PLANNING AMENDMENT

Application No. H0110593102 | A1

Description: Proposed telecommunication equipment plus 15
metre high monopole

Amendment: One 600 millimetre transmission dish at 15 meters in lieu of
300 millimetre dish at 13.85 metres.

Drawing Title
CIVIL/STRUCTURAL DETAIL DESIGN
NORTH ELEVATION

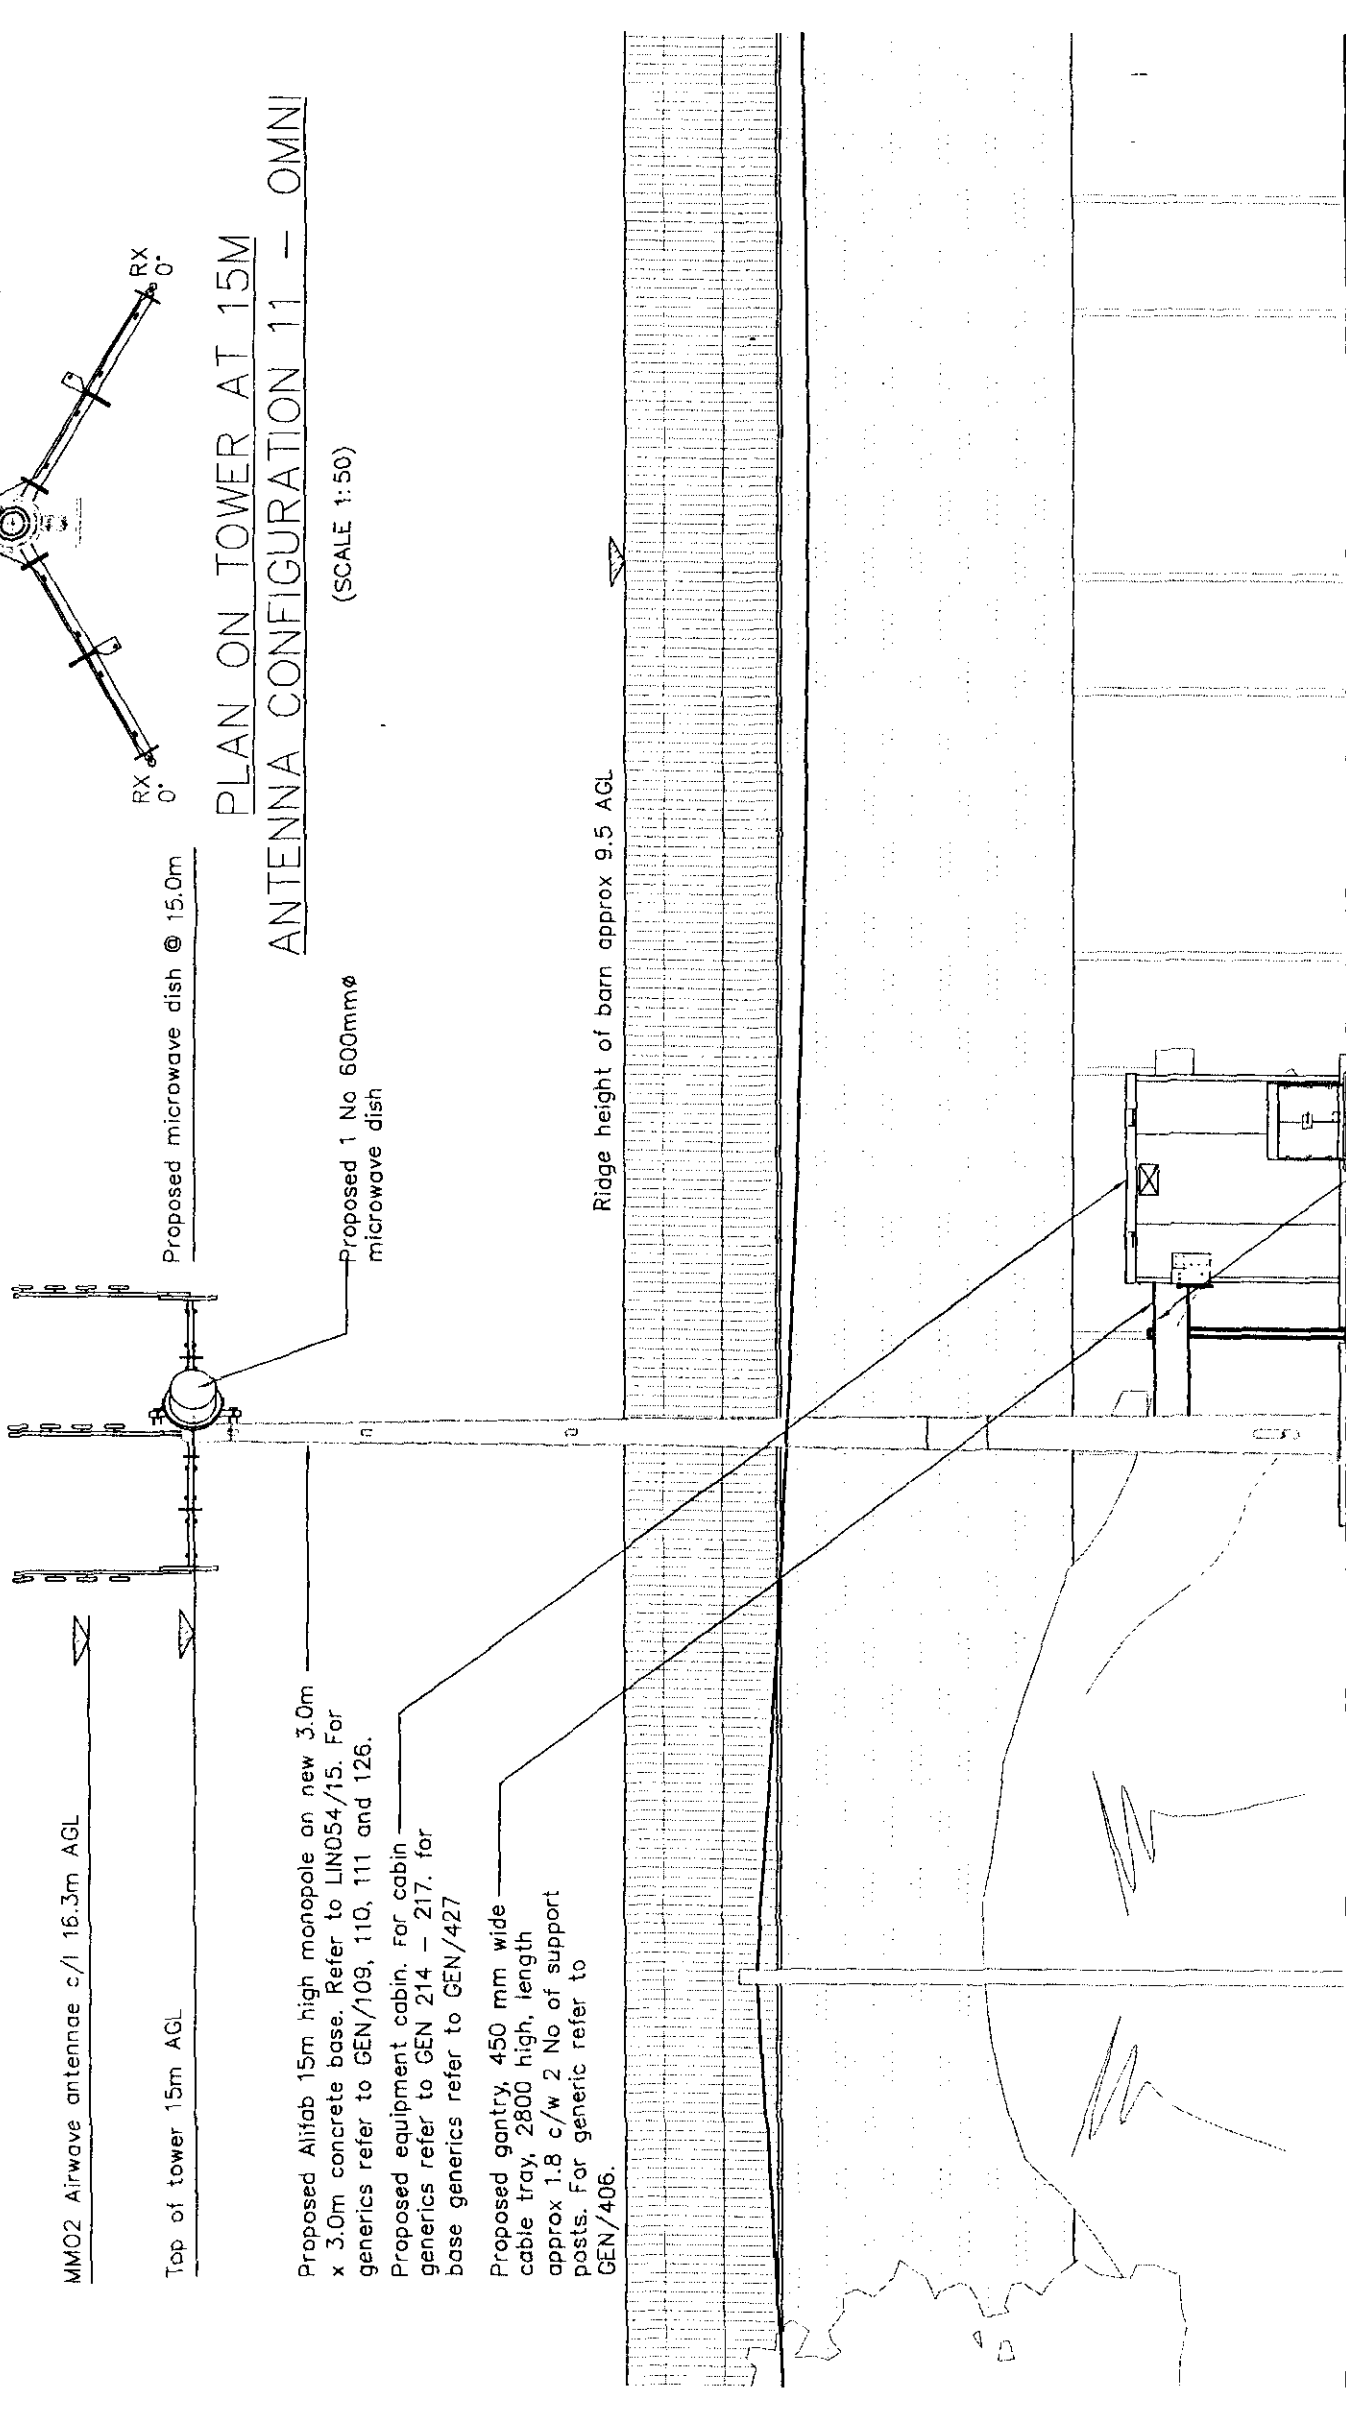
Description: 1 no. 600mm transmission dish @ 15m in lieu of 300mm dish @ 13.85m.
